Application for Listed Building Consent for new entrance/driveway, restoration of external building at the front of the property. Restoration of walled garden, front and rear. Adjustment of levels around the property. Restoration of all windows and small front porch area. Two storey extension including demolition of existing extension.

Lyminster Cottage Lyminster Road Lyminster

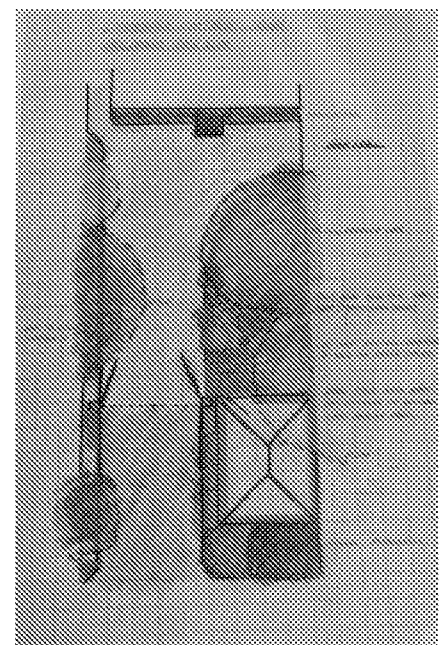
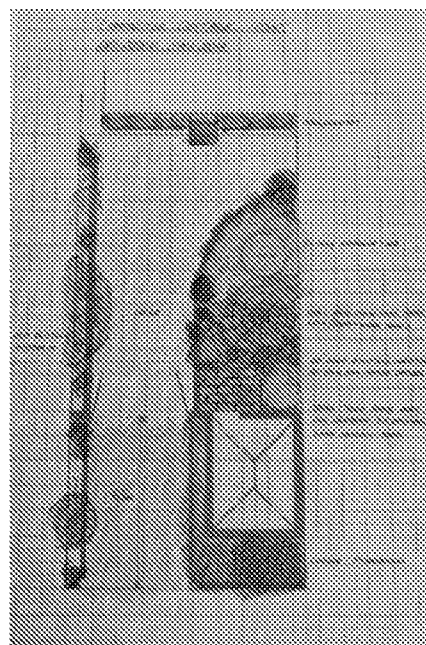
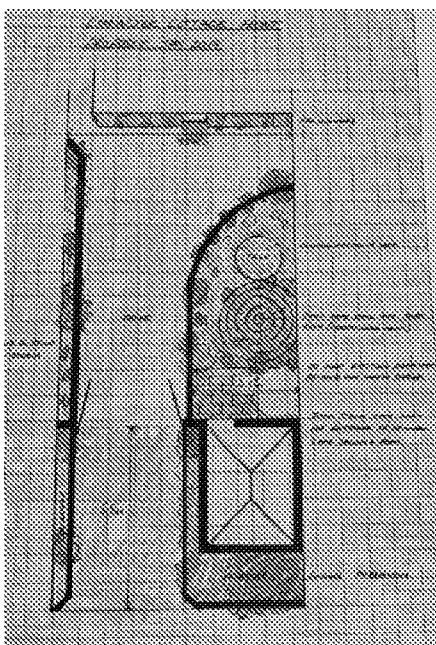
The significance of this part of the conservation area lies in its semi-rural character formed by the informal pattern of space and buildings of varying age, size and form. An important contribution to the significance also lies in the extent of front boundary flint walling which is visually attractive and also forms a unifying feature in the street scene. The loss of flint walling is always regrettable, not only through its age but also because it can be rarely reproduced to the same quality of construction or appearance and as such tends to be a finite resource.

The Panel fully appreciate the positive aims and aspirations of the applicant towards the improvement of the building as indicated in the Heritage Statement. However, the Panel's remit is to consider the effect of the proposals on the conservation area. As such it considers that to permit the removal of a significant section of the front boundary walling to form a vehicular access will detract from the character and appearance of the conservation area and also the setting of the Listed Building. It could also set a precedent for similar detracting proposals elsewhere in the historic environment of the District where historic buildings lacking vehicular access is not a rare feature.
